The Member Secretary,
Chennai Metropolitan
Development Authority,
No.1, Gandhi Irwin Road,
CHENNAI -600 008.

Letter No. **A2/37112/2003**

Dated: **9.3.2004**

Sub: CMDA - **Planning Permission - Construction of Ground Floor & First Floor with one dwelling unit Residential Building at Plot No.14, Old S.No.1, New S.No.1¹⁰⁵ (patta) of Sholinganallur Village 16¹⁰⁵ 170¹ (V.C.P Golden Beach South Part-I) Development charges and other charges to be remitted - Regarding.**

SITE CUM GROUND FLOOR PLAN

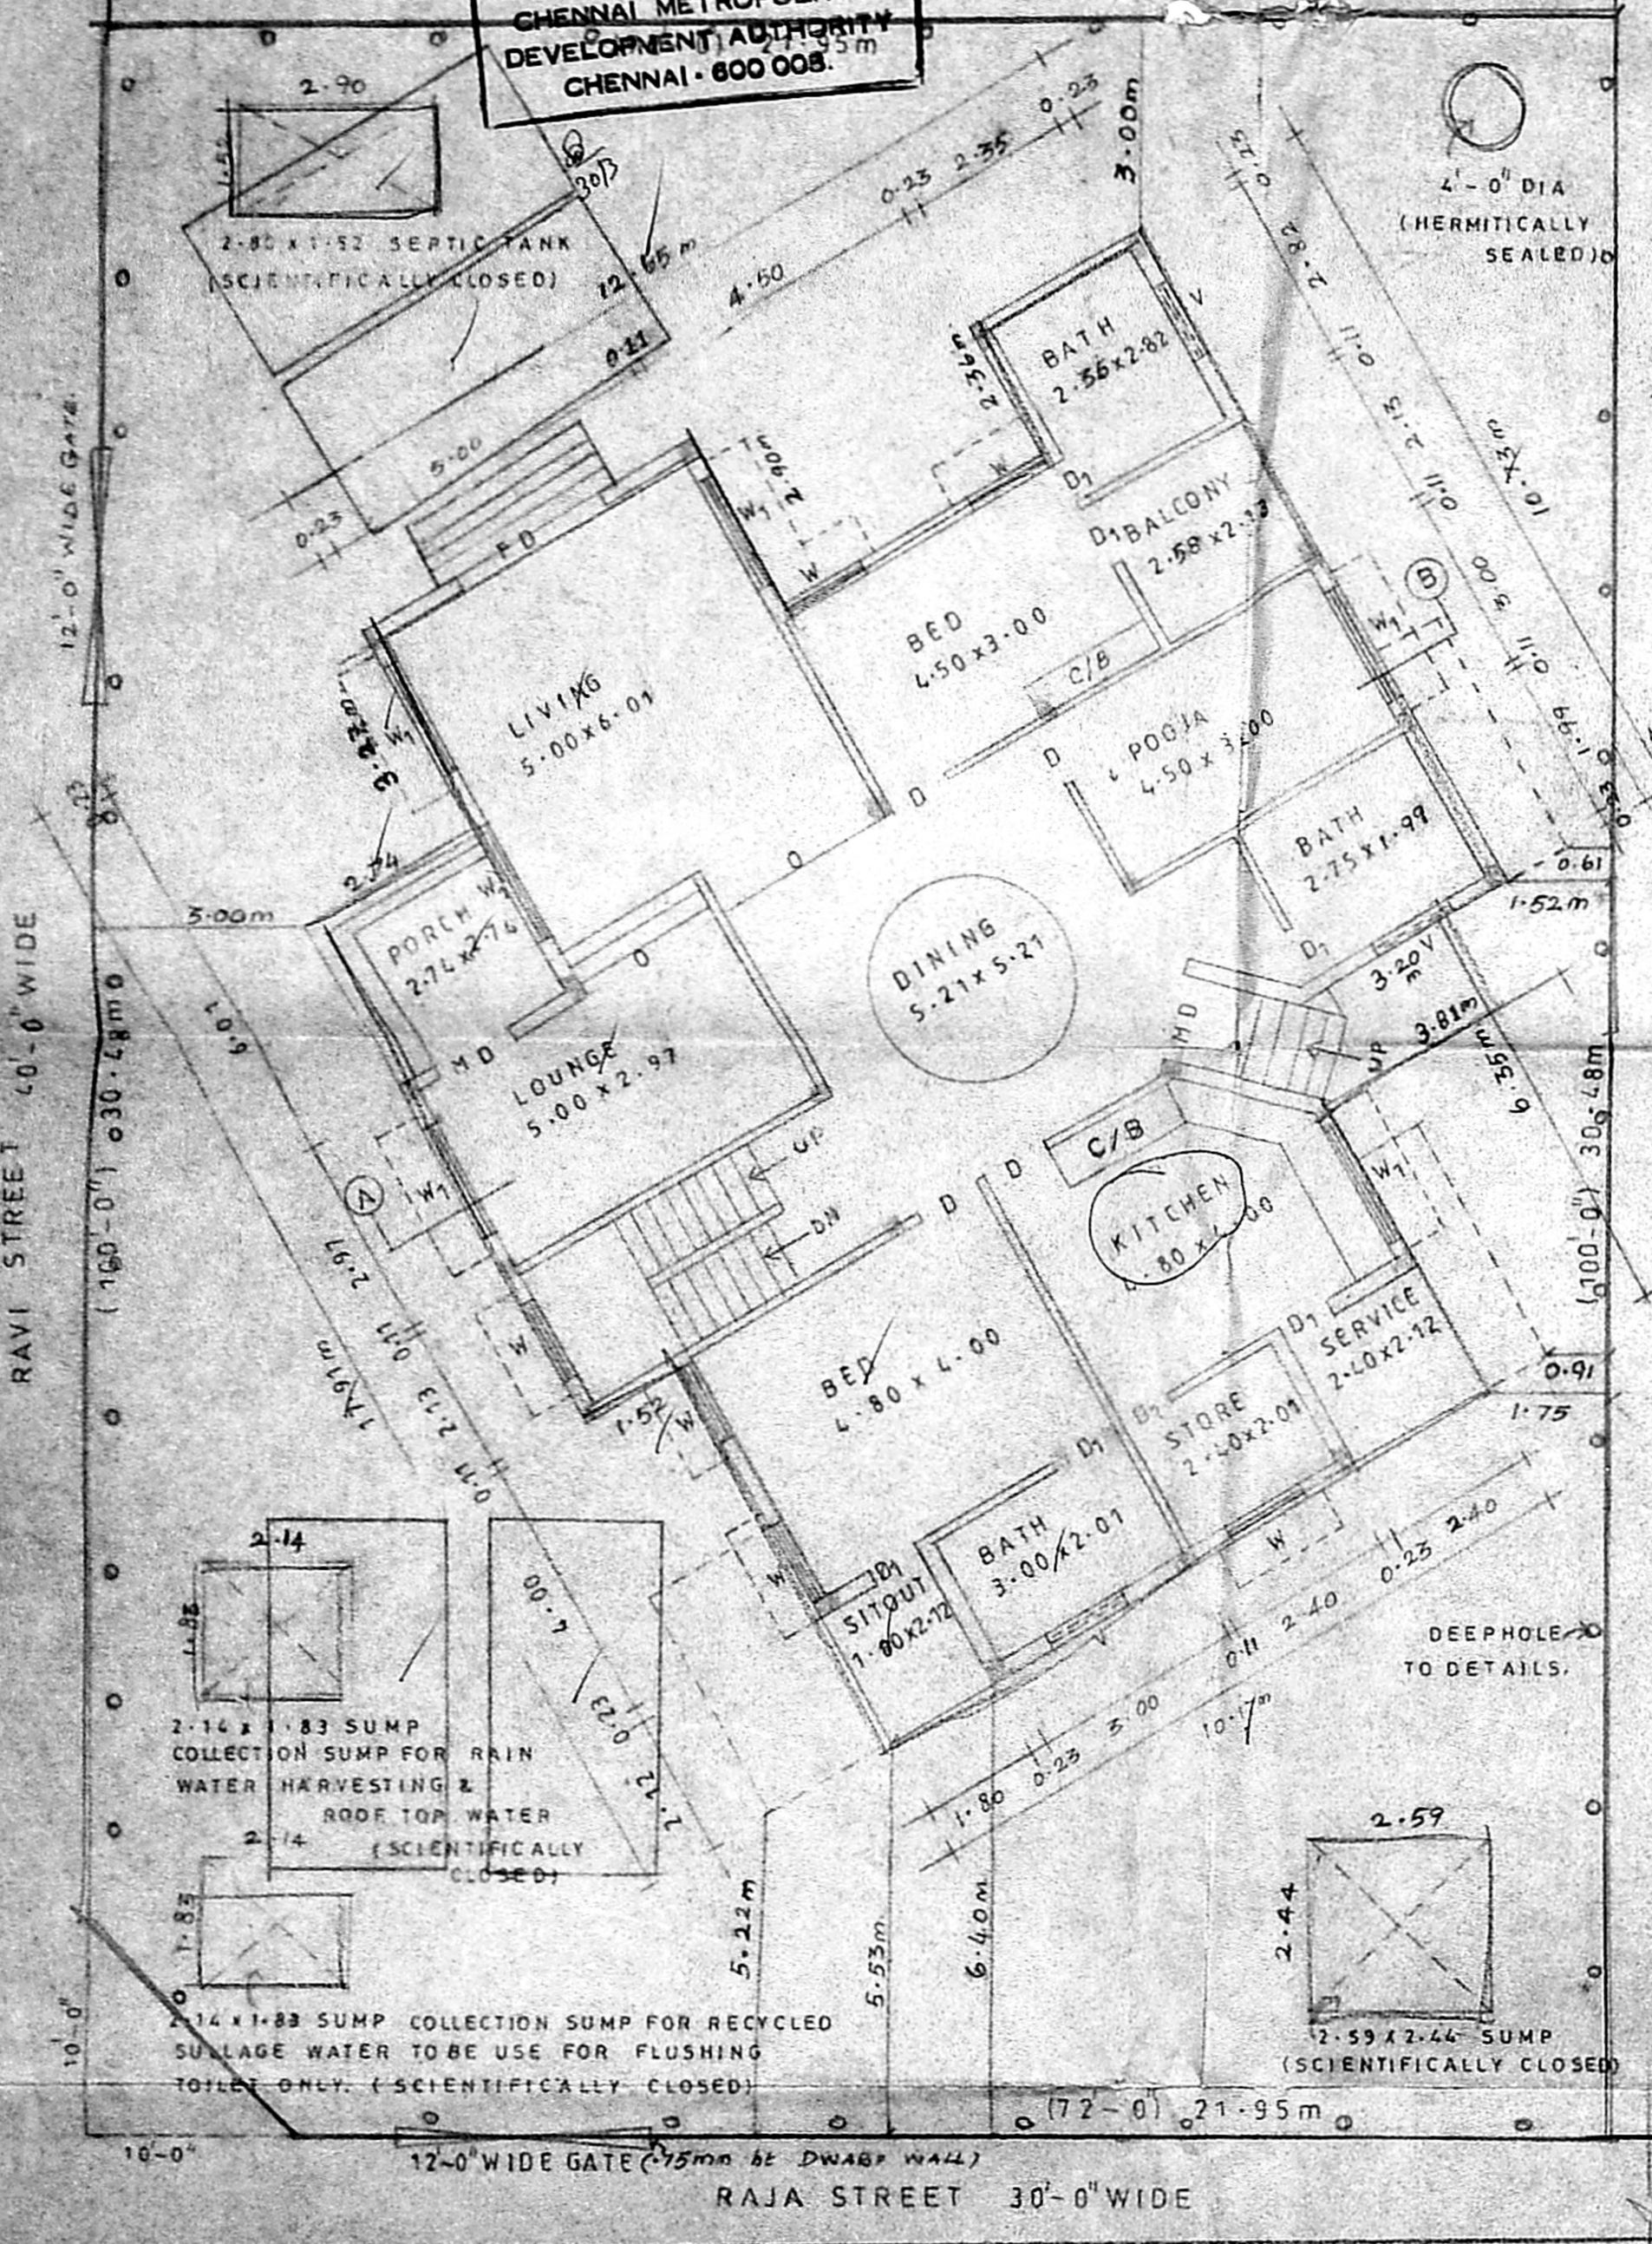
- a) Rain water conservation regulations stipulated by CMDA should be adhered to strictly.
- b) 5 copies of Revised plan satisfying four car parking lots of size 2.50m x 5.0m and mentioning the approved no correctly in the title.
- c) Copy of the approved layout plan duly attested by Local Body official.
